CITY OF ALBUQUERQUE

March 25, 2025

**RE: Christensen Oral Surgery
9378 Valley View Dr. NW
Grading & Drainage Plan
Engineer's Stamp Date: 11/22/2024
Hydrology File: C13D025F
ABQ-PLAN File: HYDR-2025-00034**

DRAWN BY MR
DATE 12/16/2024
2024061_GR
SHEET # **1.0**
JOB # 2024061

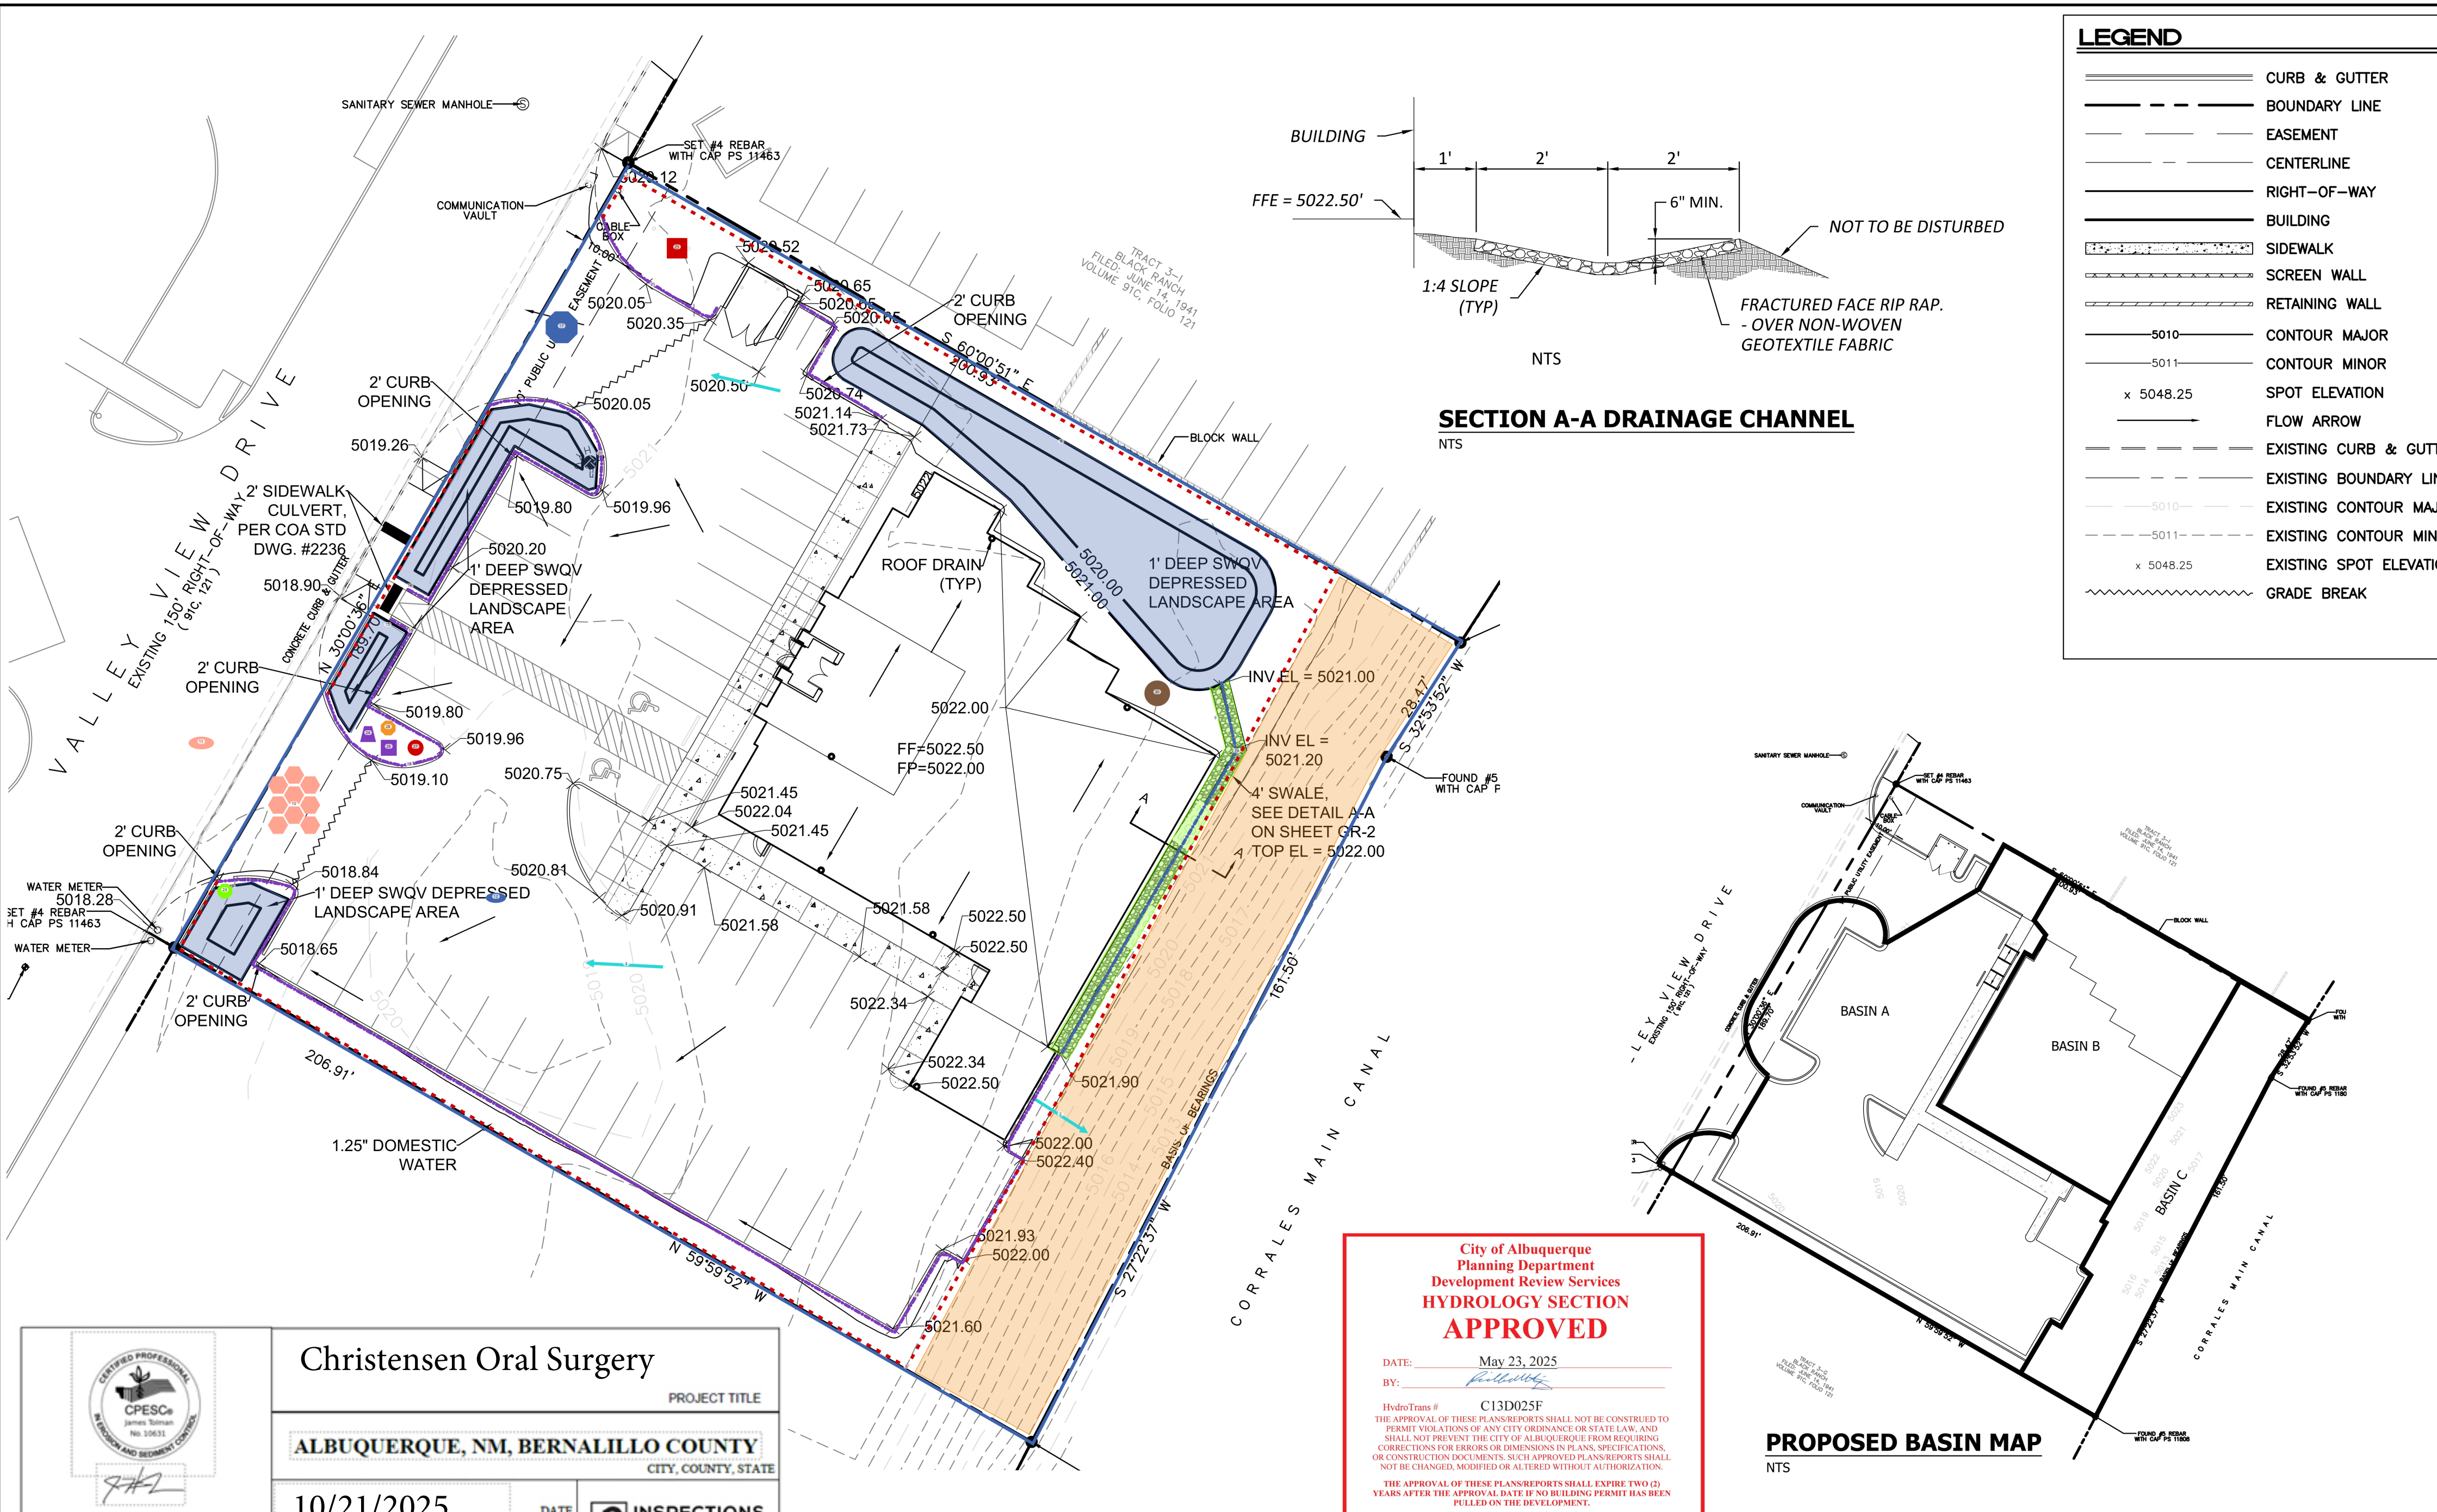
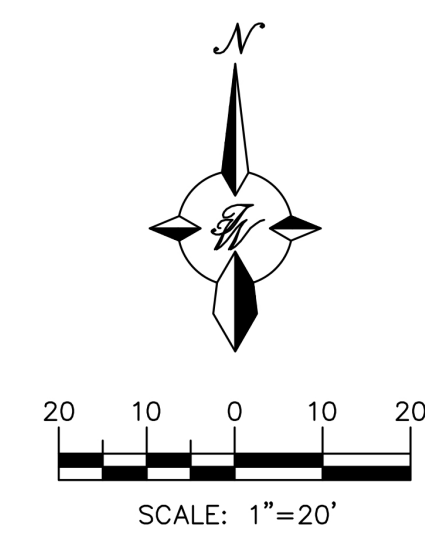
1. Sheet 1.0: Review and revise to show SWQV ponds together with sidewalk culverts for each pond as intended to discharge through curb openings along the proposed curb alignment onto Valley View Dr. directly, and not at back of the proposed sidewalk / pedestrian refuge area. Stormwater being discharged from SWQV ponds should be through sidewalk culverts with outlets at the gutter alignment. The proposed 2-foot curb openings will still direct stormwater runoff onto the pedestrian walkway area, which is not acceptable.

2. Remove the paragraph about water quality volume in the AMAFCA pond in the PROPOSED DRAINAGE dialogue, and all re-submittals require an updated P.E. signature and date.
